TfNSW Reference: REN 25/00088/005, SF 2025/058625
DPHI Reference: SSD-77238990

**STATE SIGNIFICANT DEVELOPMENT APPLICATION (SSDA) SSD-77238990
RESPONSE FOR AMENDMENT REPORT
SOUTH COREE BATTERY ENERGY STORAGE SYSTEM (BESS)
384 BROCKMANN'S ROAD FINLEY NSW**

TAB A – Outstanding matters

TAB B - Design review comments – strategic design

Figure A-1 Concept intersection design for the Riverina Highway and Canalla/Martenellis Roads

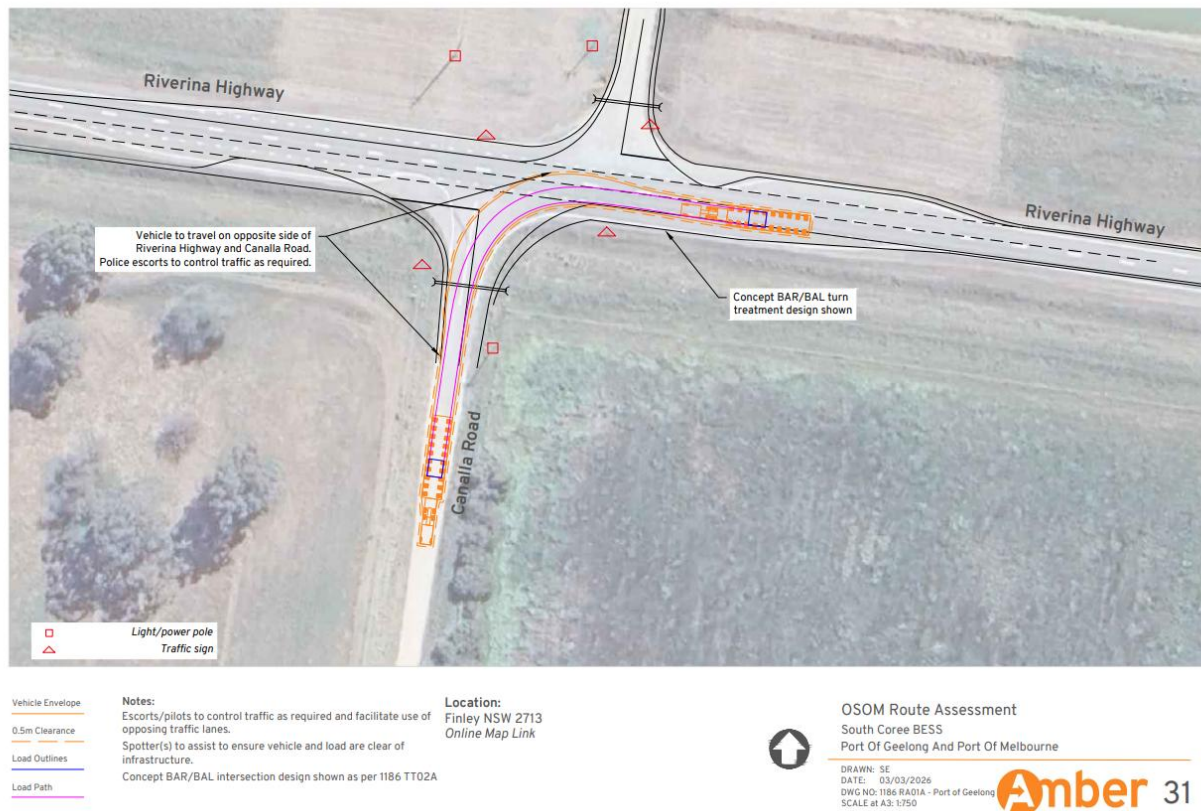
- Both the South Coree BESS and Finley BESS projects propose upgrades to the Riverina Highway/Canalla Road/Marantellis Road intersection. Coordination between the respective proponents will be required to ensure a compliant, integrated, and safe final intersection outcome.

Bus bay design and compliance

The Applicant must demonstrate that the final bus bay design complies with the requirements of the **TfNSW Supplement to Austroads Guide to Road Design (TS 02642)**, including:

- Retention of a 3.5 m bus bay width.
- Retention of the proposed bus bay length and associated acceleration area.
- Provision of a 10:1 entry taper (approximately 35 m in length); and
- Provision of a 5:1 exit taper.

App E - 1186 TT02A	Swept paths for Martenellis Rd shows 19m semi-trailer. Table 2 notes BAR/BAL has been considered as part of the design. Concept layout does not show any information for BAR/BAL requirements.	Open
App E - 1186 TT02A	SISD has not been shown for Martenellis Rd	Open
App E - 1186 TT02A	Pavement markings to be confirmed at WAD. HW20 Centreline to match existing (i.e. DL4)	Noted To be confirmed at WAD

The final bus bay design is to be further developed and submitted to TfNSW for review and endorsement through the **Works Authorisation Deed (WAD)** process. Compliance with the above requirements is to be demonstrated as part of that submission.
